CITY OF ALBUQUERQUE

March 15, 2013

**Re: Hampton Inn at the Sunport Grading and Drainage Plan
Engineer's Stamp date 03-06-2013 (M-15/D043)**

ENGINEER'S SEAL  DAVID SOULE P.E. #14522	HAMPTON INN @ SUNPORT GRADING AND DRAINAGE PLAN  <i>Rio Grande Engineering</i> 1806 CENTRAL AVENUE SE SUITE 201 ALBUQUERQUE, NM 87106 (505) 872-0999	DRAWN BY WCUJ
		DATE 2-04-13
		21226-LAYOUT-7-05-12
		SHEET # —
JOB # 21226

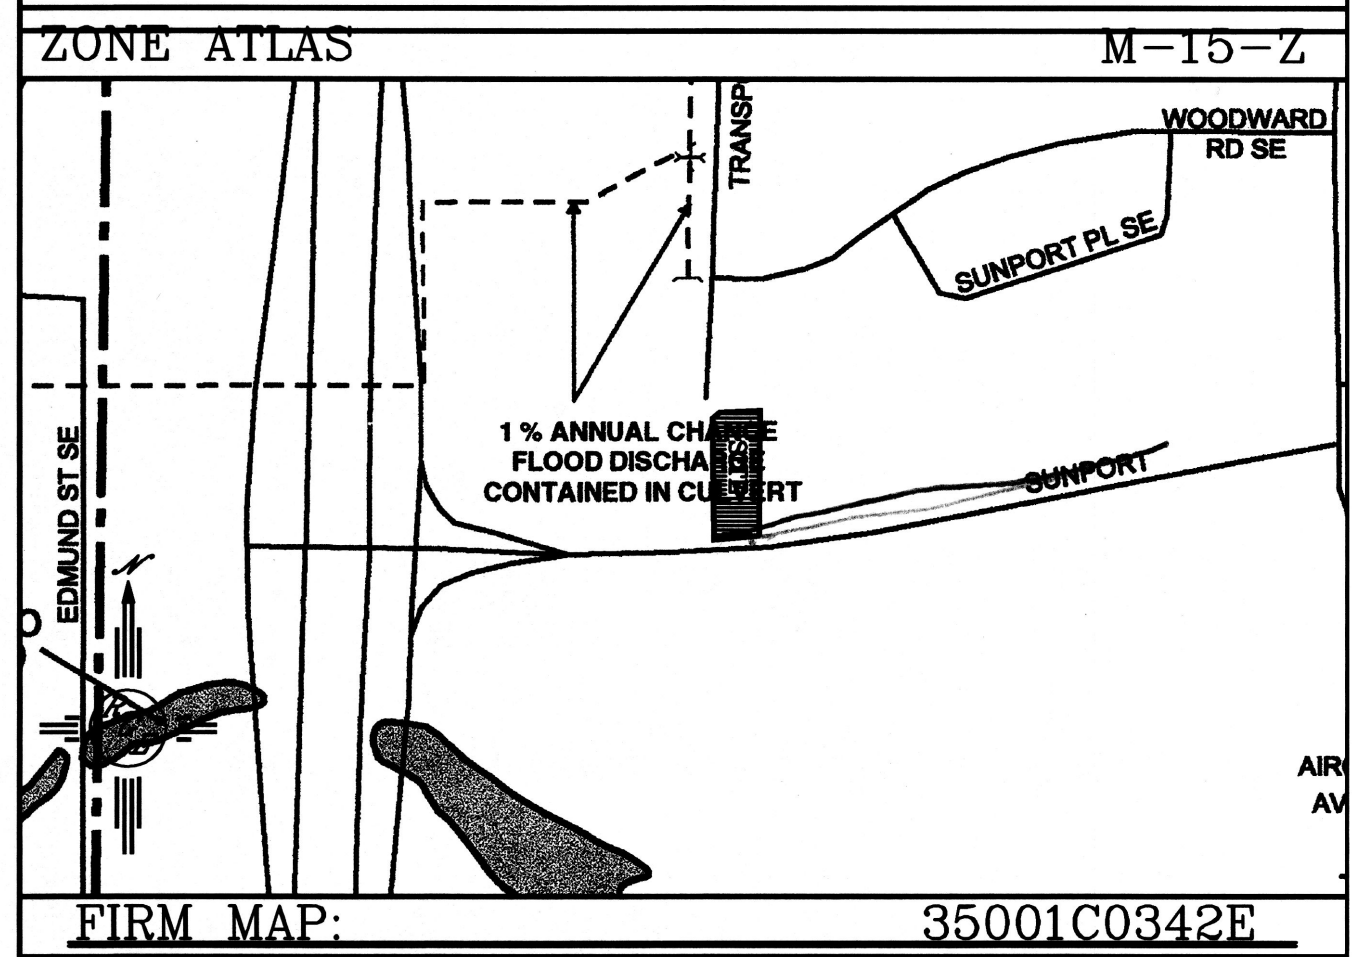
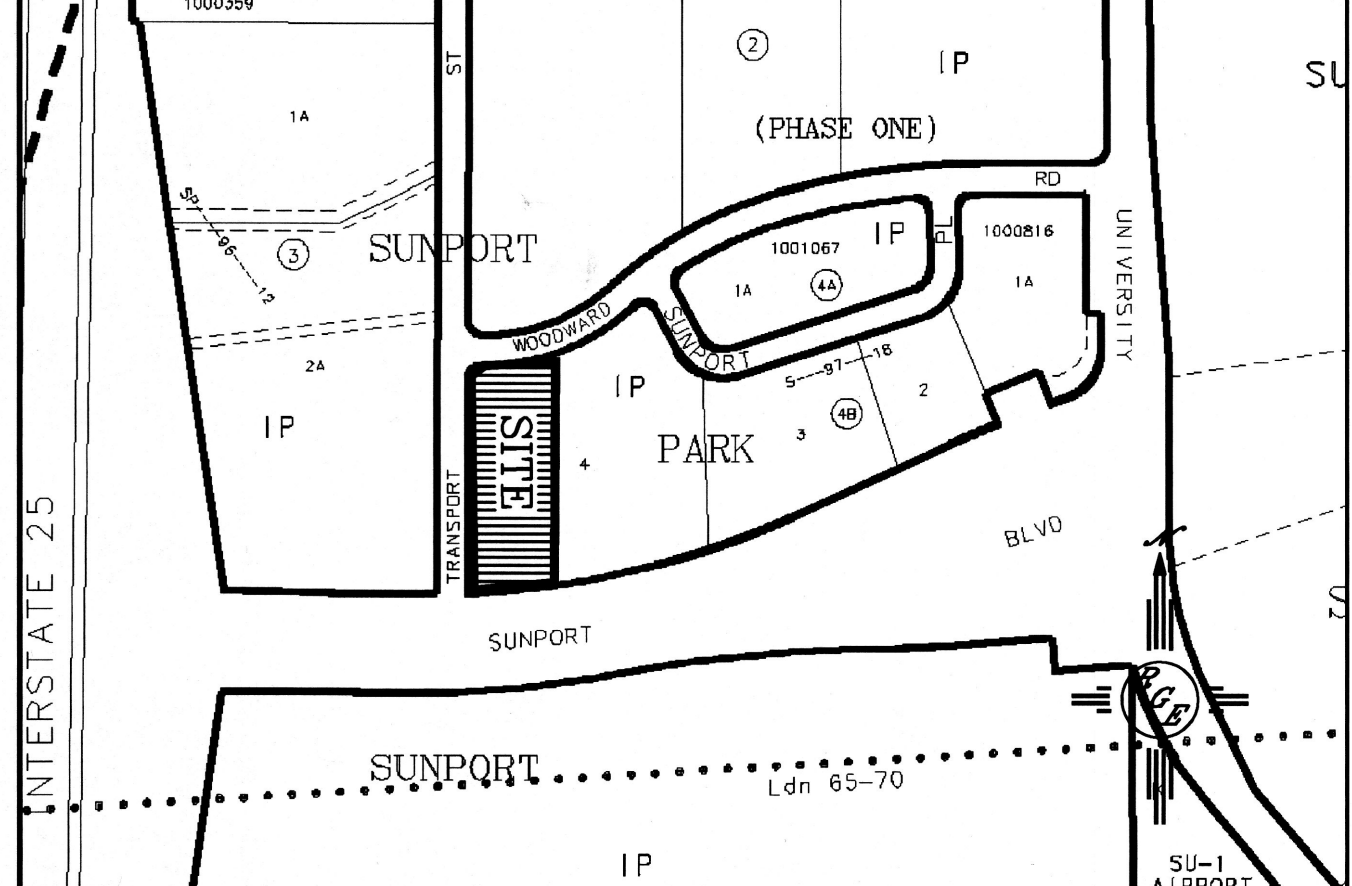
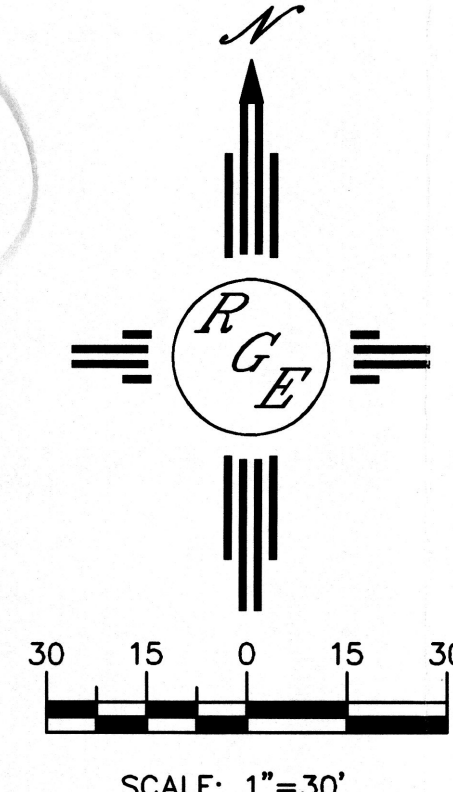
- Please show the central basin divide on the grading plan.
- Provide direction of roof flows and locations of downspouts to support the basin boundary delineations.

- Quantify any off-site flows from the east of the project and include these flows in the drainage calculations provided.
- Provide spot elevations for the pedestrian connection into the City sidewalk to ensure ADA requirements are met.

- Additional spot elevations along the east side of the building are needed. Show the locations of all exterior doors to the building.
- Spot elevations are needed at the backside of the sidewalk along the public right-of-way.

- Show finish contours between the retaining walls along the southern boundary of the property. Provide section details of both the southern walls and eastern walls. Existing contours should be represented by dashed lines.

- Additional elevations are required for all proposed retaining walls.
- The hatching at the building entrance makes it very hard to read the information being depicted.

- Two finish floor elevations are given for the proposed building; it appears that one of these elevations should be finish pad.
